Our ref: NE/2014/121520/02-L01
Your ref: S6/2014/2292/FP
Date: 21 January 2015

**Lands Southeast Of Northaw Road East (Cattlegate Farm), Cuffley,
Hertfordshire, EN2 8AU**

**Installation of pipework to provide a primary distribution heat network.
Submission of a flood risk assessment**

Drawing Title:-
WATERCOURSE CROSSING DETAIL (NORTHAW BROOK)

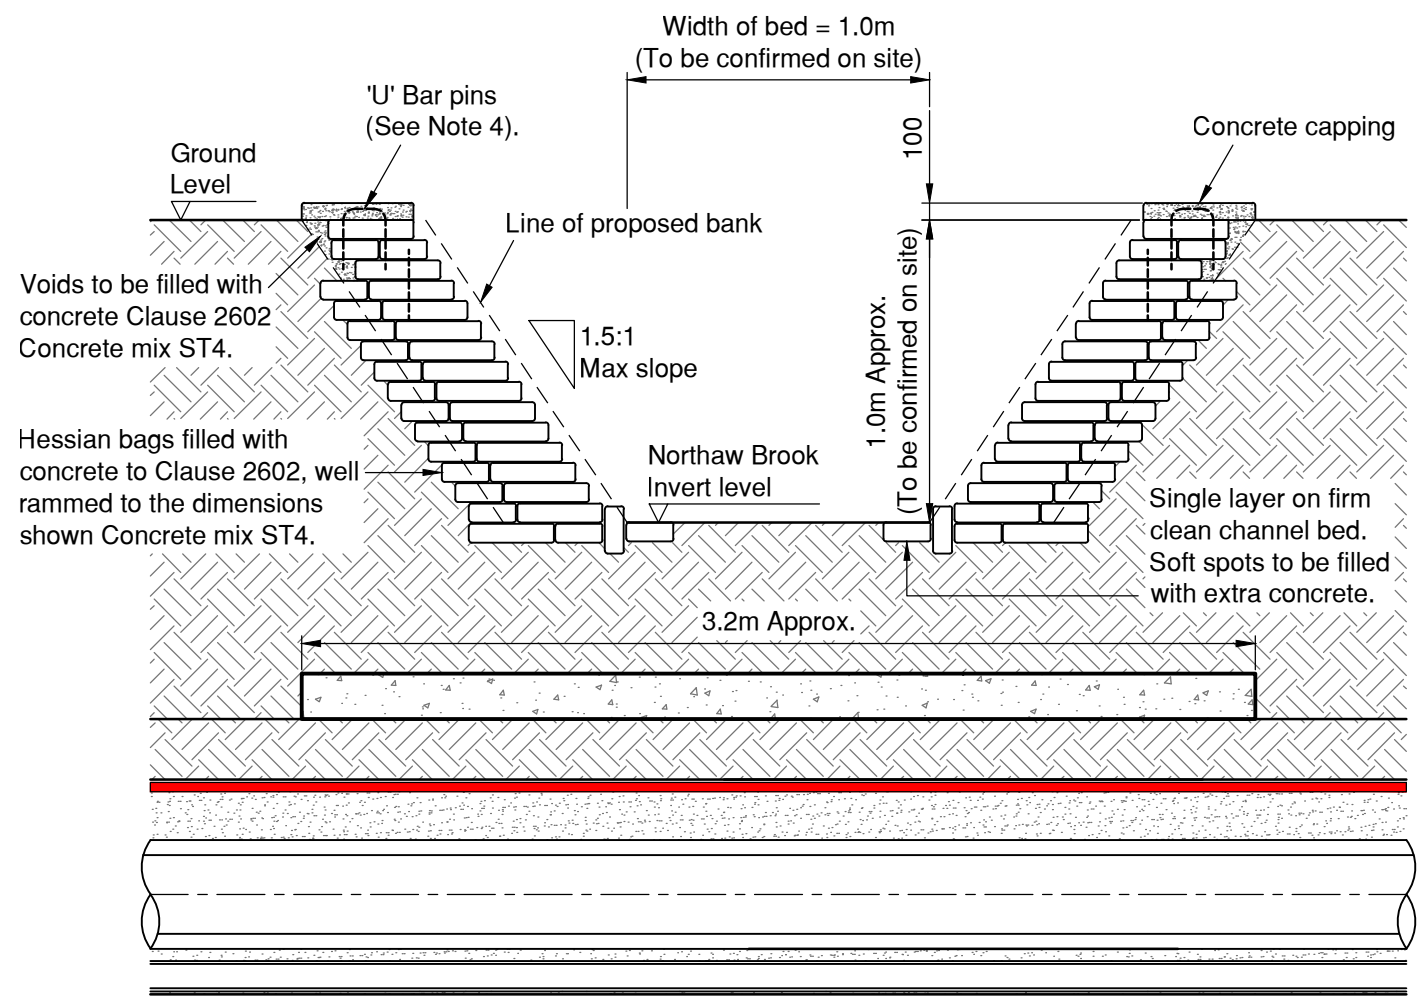
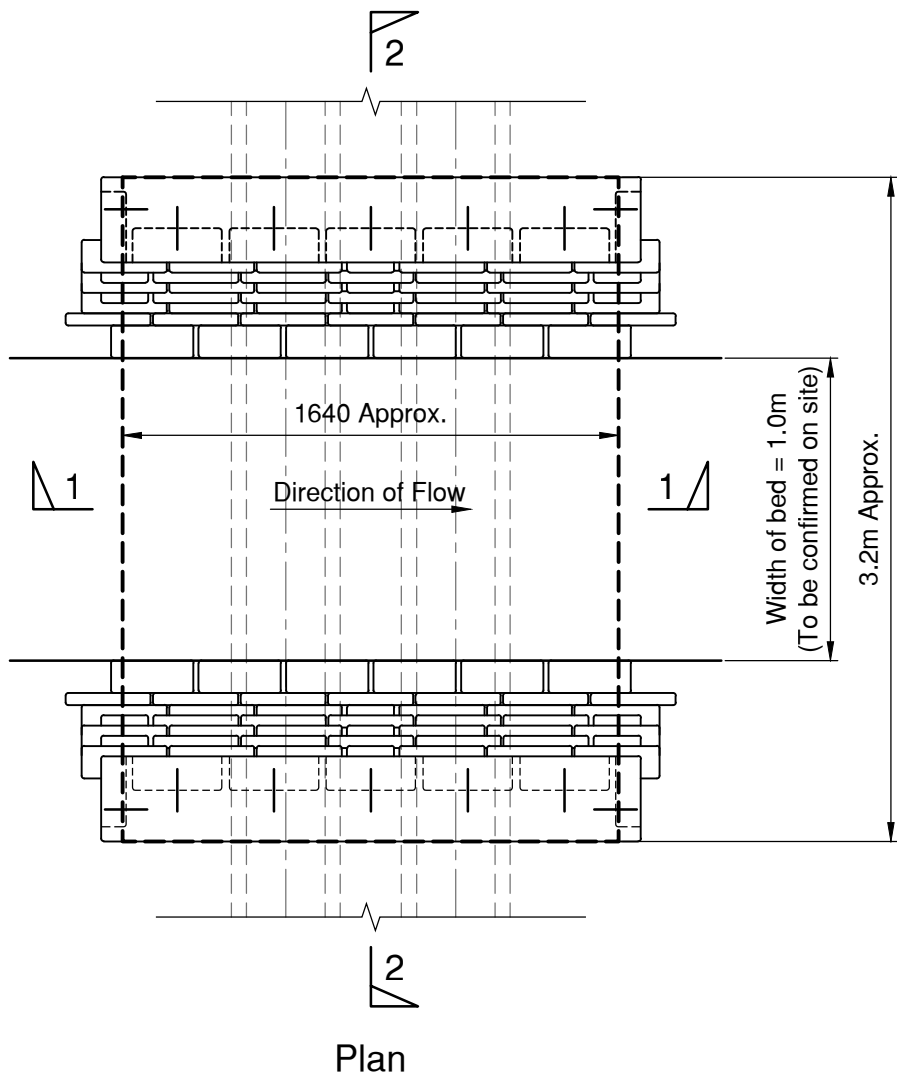
Under the terms of the Water Resources Act 1991, and the Thames Land Drainage Byelaws 1981, the prior consent of the Environment Agency is required for any proposed works or structures, in, under, over or within 8 metres of the top of the bank of the Hempshill Brook and Northaw Brook, designated 'main rivers'.

Our usual requirement where a pipe crosses under a river is that the pipe invert is positioned at least 1 metre below the level of the river bed and that directional drilling techniques are used. The pipe should be set at the same level when within 8 metres of the river. Please contact us on 01707 632419 for further information.
